Phone: 0300 123 6780
Email: Kathryn.Walsh@lancashire.gov.uk
Your ref: 3/2024/0906
Our ref: 3/2024/0906/HDC/KW
Date: 16 December 2024

Location: Lower Fold Stables Northcote Road Langho BB6 8BE
Proposal: Advertisement consent for two free-standing 1500mm x 1000mm composite signs on reverse mounted black steel posts and one 2800mm x 800mm composite tray sign mounted on cladding of existing barn.
Grid Ref: 370347 435751

DESCRIPTION
Entrance signs

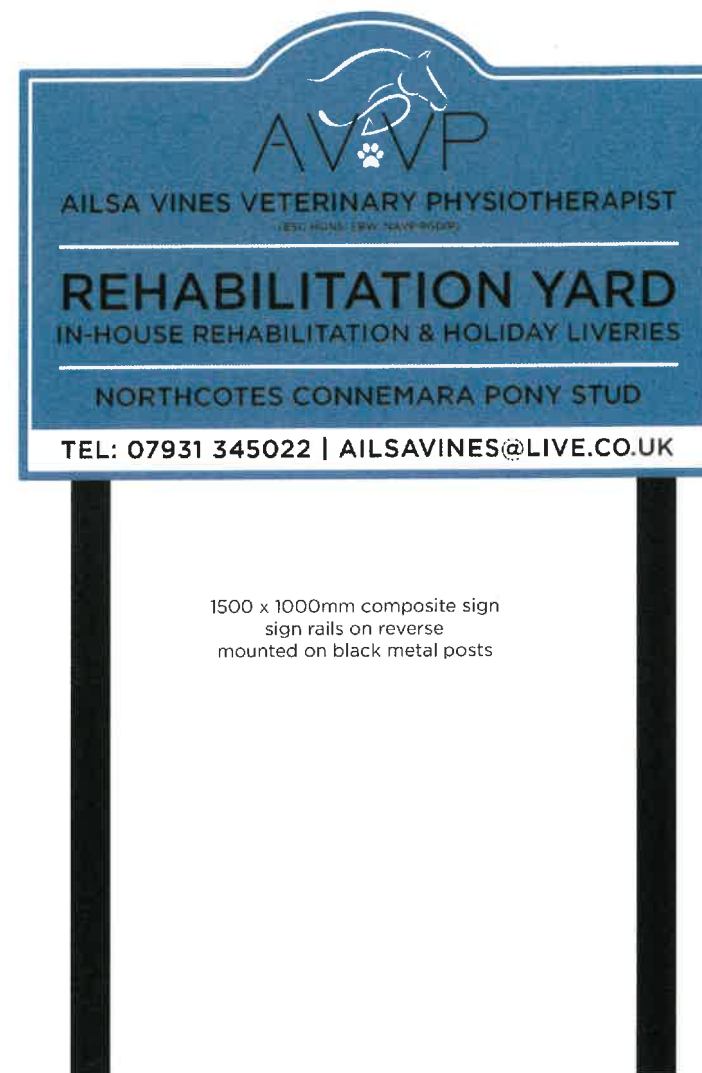
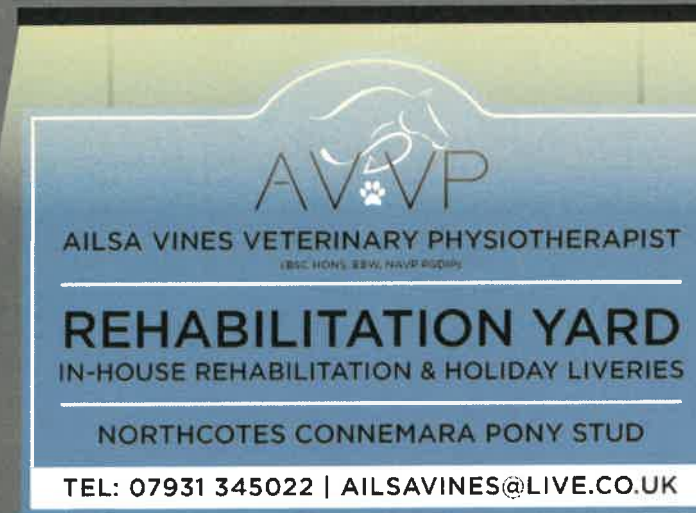
The LHA has reviewed drawing 6925 P01A and noted that the proposed signage is to be set back at least 3m from the carriageway edge which should ensure that the signage does not interfere with the visibility splay of vehicles exiting the site.

1. Any illuminated advertisement shall be designed so that:
 - No part of the source of the illumination shall at any time be directly visible to users of adjacent adopted highway.
 - Static illumination is provided, and the sign shall not feature intermittent or flashing lights.
 - The level of illuminance shall not exceed the maximum level found within the Institution of Lighting Engineers (ILE) document PLG 5 Brightness of illuminated advertisements or its equivalent in any replacement guide.
 - Moving features are not provided.
